From: [Holly Palmer](#)
To: [Emily Dickson](#)
Cc: [Brendon Roberts](#)
Subject: Eastern Creek Business Hub (SSD 5175 MOD 4 and SSD 8588 MOD 2) - Rooty Hill Road South, Eastern Creek - BCC Response
Date: Thursday, 16 May 2019 2:28:33 PM
Attachments: [image003.png](#)
[image004.png](#)
[image008.png](#)
[SSD 5175 MOD 4 and SSD 8588 MOD 2 - Notification of Modification Letter to Council.pdf](#)

SSD 5175

These amendments are based on the updated civil drawings by Henry and Hymas 17D83_S96_C Series dated 20/03/19 for the proposed business development drainage basins.

DISCHARGE CONTROL PIT
SCALE 1:25

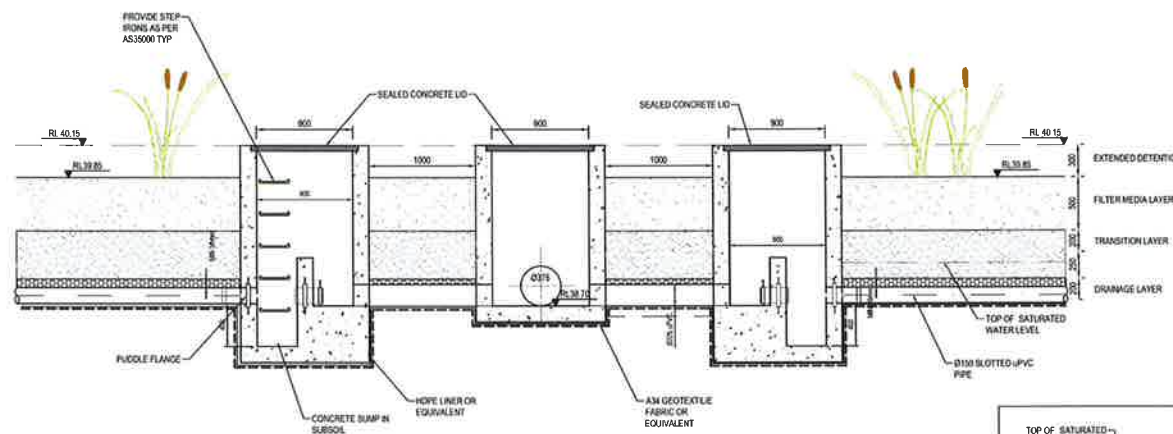
m) The existing outlet control for basin 2 is incorrect. Electronic hydrologic models are to be provided for the detention basin design to ensure that the predevelopment flows do not exceed the post development flows for all storm durations and for all ARIs from 1 year to 100 year. Allow for an initial pervious loss of 15 mm for the pre development case and the post development losses (5 mm) as per the Engineering Guide for Development. RAFTS itself or the RAFTS hydrological model in DRAINS is preferred to allow for the 15 mm initial loss. There are currently no modelled pre development nodes for this catchment to compare to. Review storages which is not to be less than 5600 m³ that excludes the bioretention extended storage.

n) Both detention basins are to install a concrete cutoff wall under the full extent of the spillways to minimise risk of seepage flows and failure. Amend drawings C230(03) and C240(03) by extending the cutoff wall a minimum of 400 mm below the bottom of the scour protection.

o) Provide a stilling basin at the base of the downstream spillway of both detention basins.

BIO-RETENTION LINER DETAIL
NTS

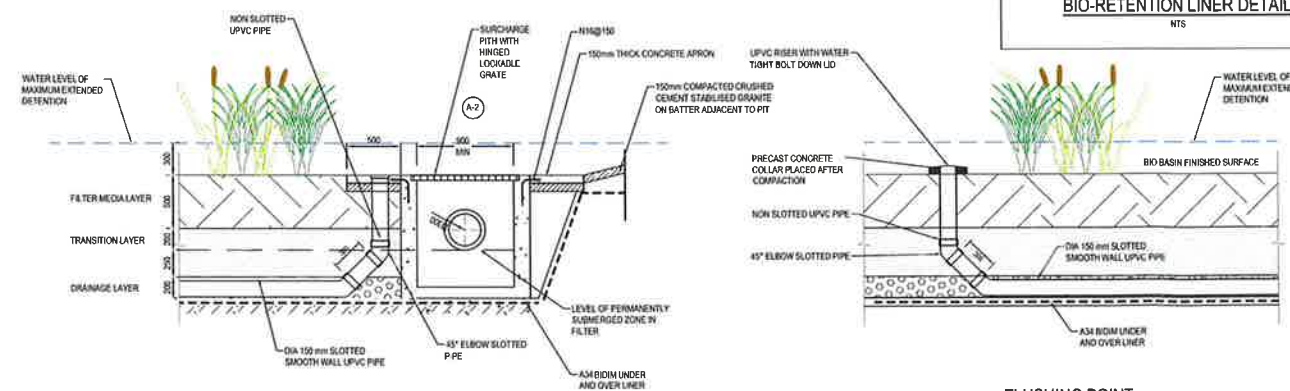
- f) ~~To provide a water source to ensure ongoing viability of the bioretention plants a saturated zone is required comprising a 300 mm transition layer and a gravel layer sized as the larger of 200 mm, or 50~~

mm above the largest subsoil pipe. The saturated zone is set to the underside of the filter media and standard pit details are available from Council. On Costin Roe Plan CD12693.00-DA45(C) under "TYPICAL BIO-RETENTION DETAIL" amend the detail to match this requirement:

i) Provide a detail of a subsoil riser for flushing and maintenance of the subsoil collection pipe. The riser is to include two 45 degree bends with a short section of un-slotted straight (minimum 300 mm) in between. The vertical riser is to stop 50 mm above the filter media and sealed with a removable screw cap.

j) Provide an intermediate riser detail for long subsoil lines, or subsoil collection pipes at maximum 20 m intervals.

k) Provide a separate pit for the collection of flows from the bioretention subsoil drainage from Basin 2 that is independent of the overflow pit or discharge control pit for on-site detention. The top of the pit is to be either sealed or set a minimum of 100 mm above the top of the 1 in 100 year detention storage. The subsoil drainage is to discharge downstream of the discharge control pit. Provide a separate subsoil collection pit for bio basin 1.
